CONSULTEE RESPONSE (Council's arboriculturist)

Planning Application Ref: P/53/22/DOC

Location: Land at Spinnaker View, Pagham

Description of works: Approval of details reserved by condition imposed under P/165/21/PL relating to condition 3-Arboricultural Method Statement and tree protection plan

**Spinnaker View**  
**Appendix 3 - tree protection plan**

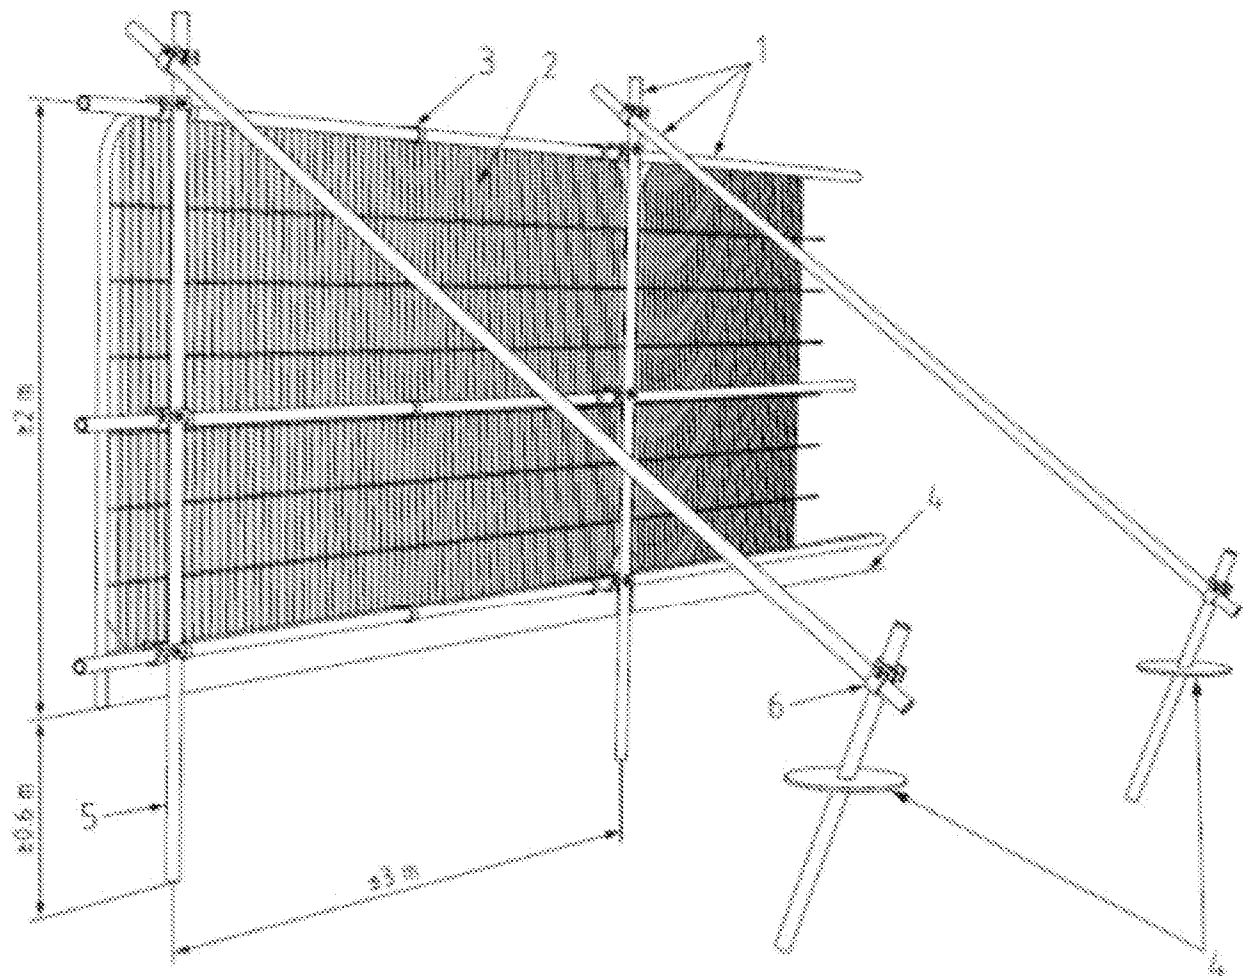
The statement and plan if strictly adhered to will ensure adequate protection of the TPO poplar tree throughout the development proposal.

The applicant has met the requirements of Condition 3.

(incl. Appendix 3 – Tree Protection Plan)
